CITY OF ALBUQUERQUE

**RE: Bedrock (LaTerra) Development
Overall Grading Plan
Engineer's Stamp Date: 06/22/23
Hydrology File: C09D011B**

Based upon the information provided in your submittal received 06/22/2023, the Overall Grading Plan is approved for Grading Permit.

BEDROCK
POND A6-1 & POND A6-2

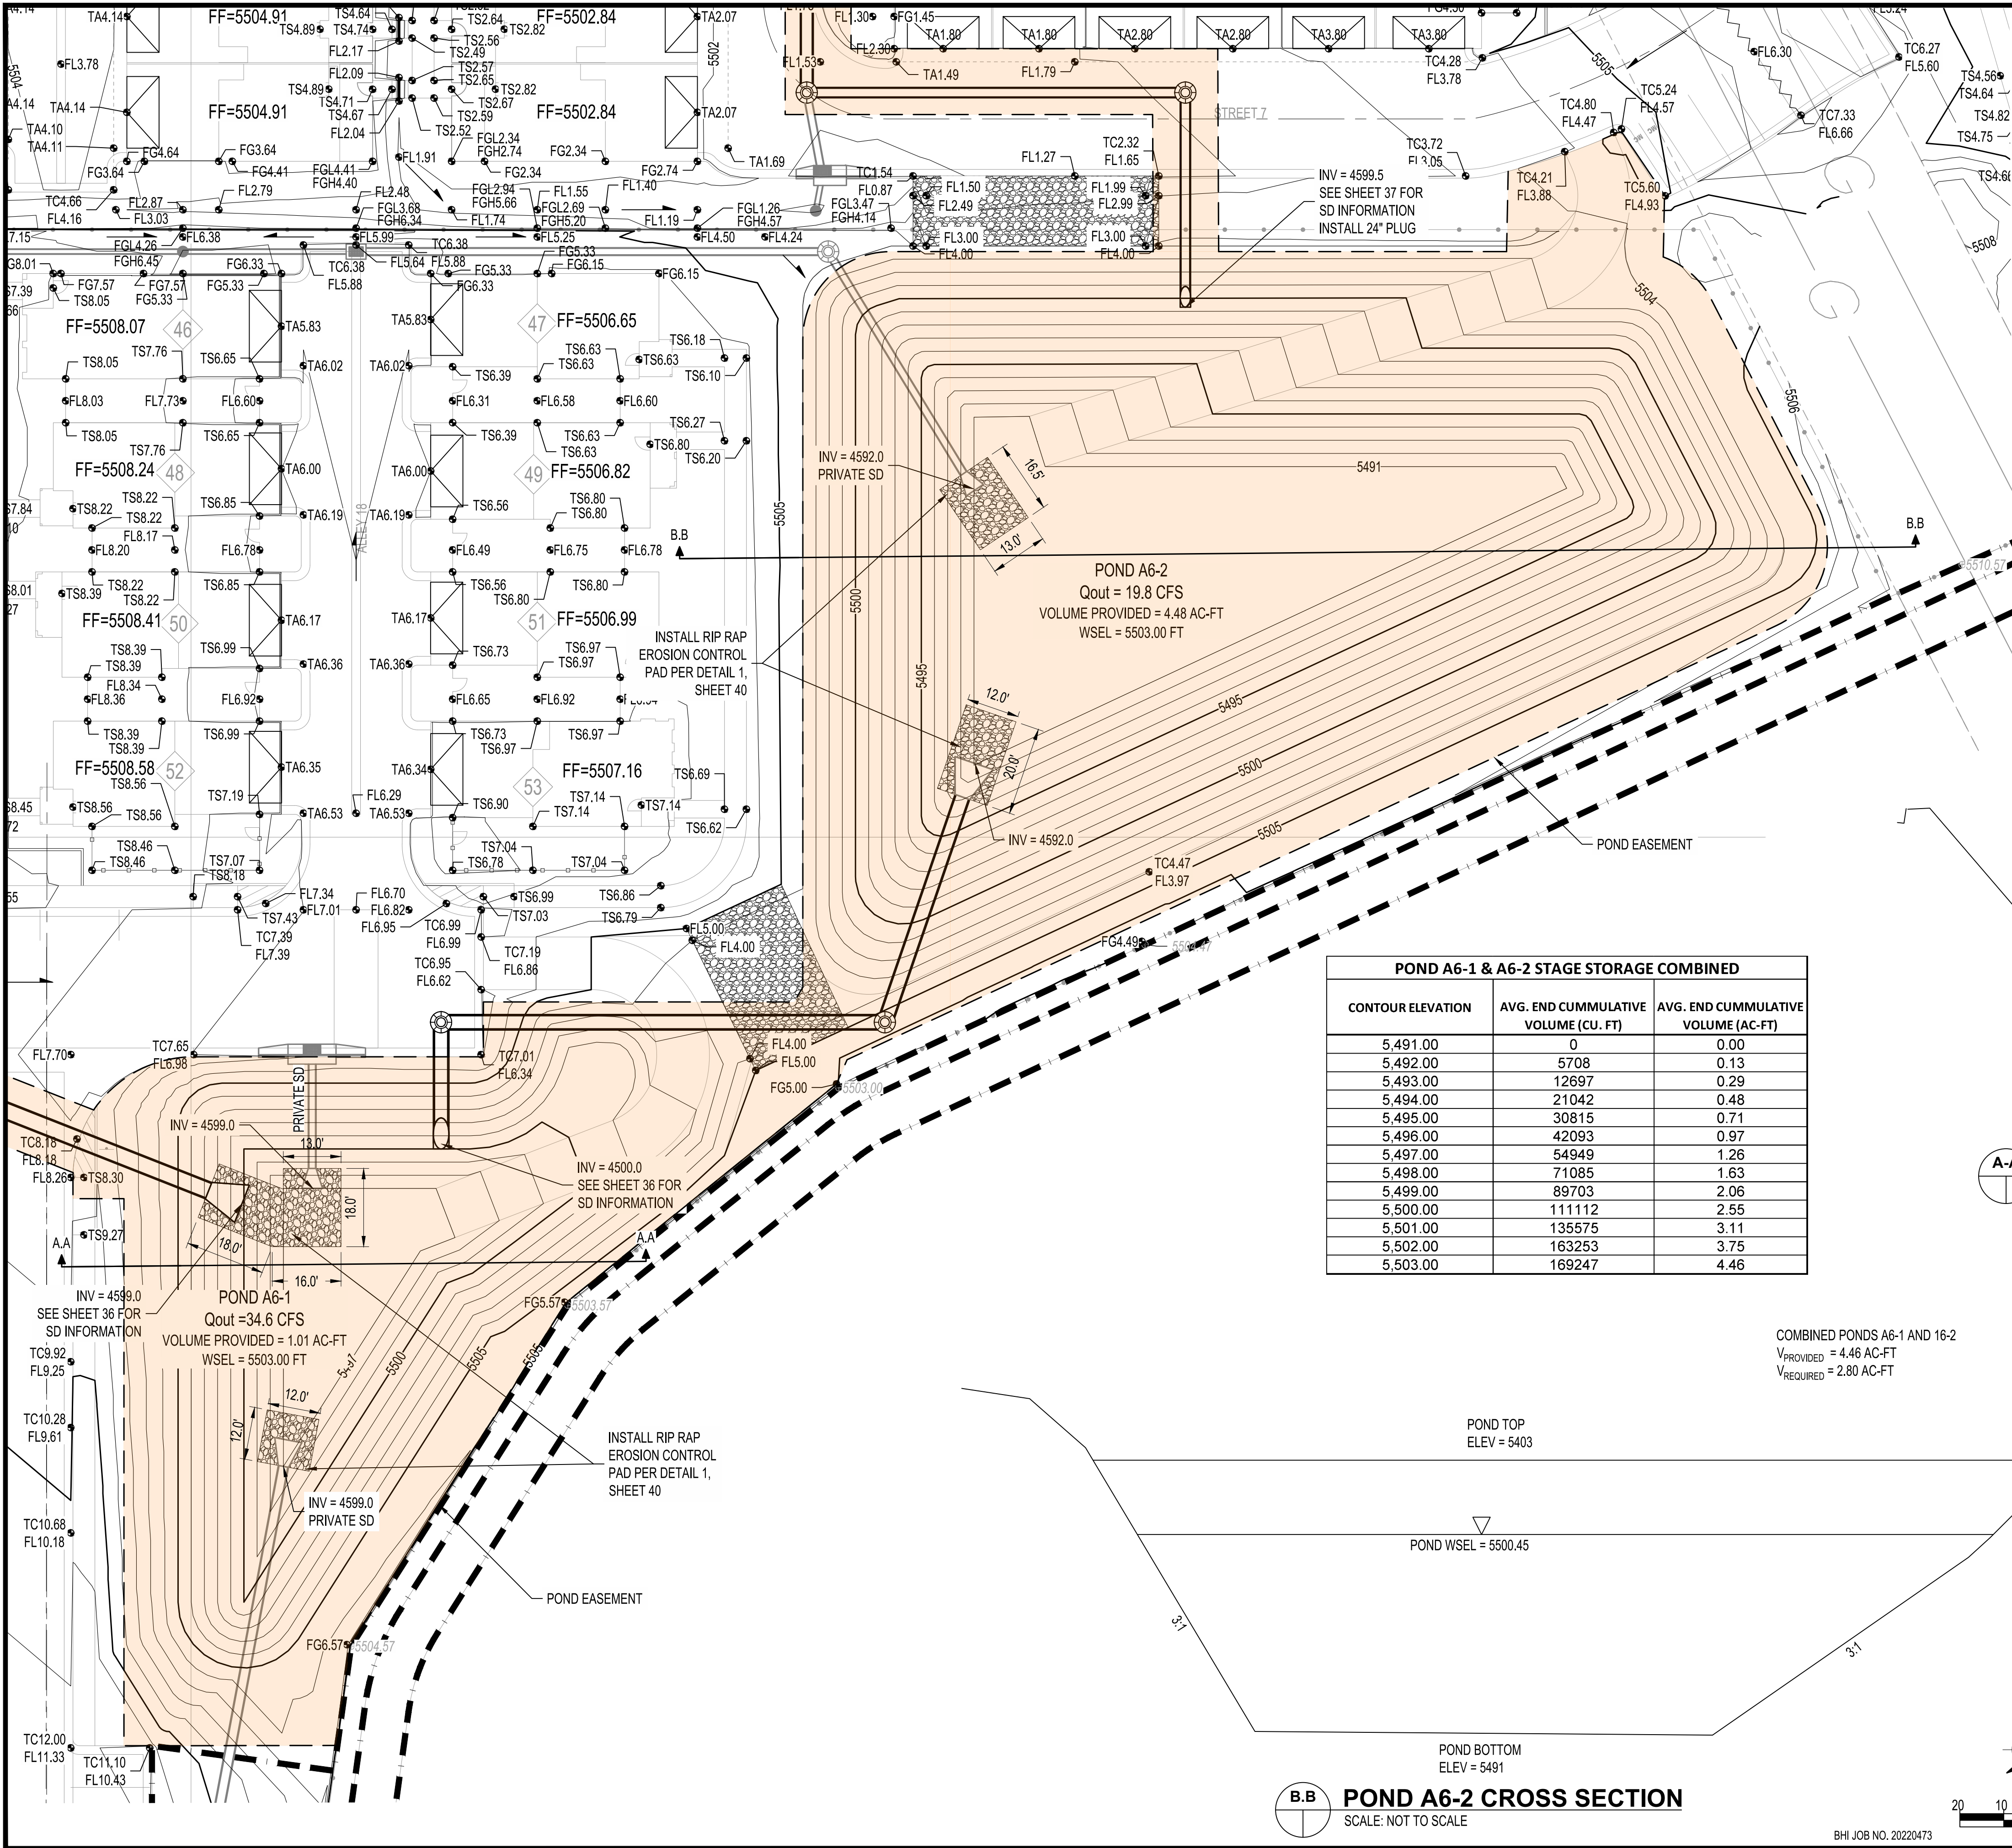
1. Please submit the Grading Plans and Amended Drainage Master Plan to Hydrology for review and approval. This digital (.pdf) is emailed to PLNDRS@cabq.gov along with the Drainage Transportation Information Sheet.
2. Please submit the Updated Master Drainage Plan XPSWMM model for review. This model needs to include all of the as-built flows from The Trails Heritage Unit 1 and Unit 2, the project's Pond D1 and Pond A6, the existing Pond A with the existing off-site pond 1.
3. Since Pond D1 and Pond A6 are public detention ponds, both needs to be in a Public Drainage Easement, have an Agreement & Covenant or the Public Drainage Easement language on the plat, both ponds need to be fenced with a gate and have a maintenance drive pad and ramp down into the pond.
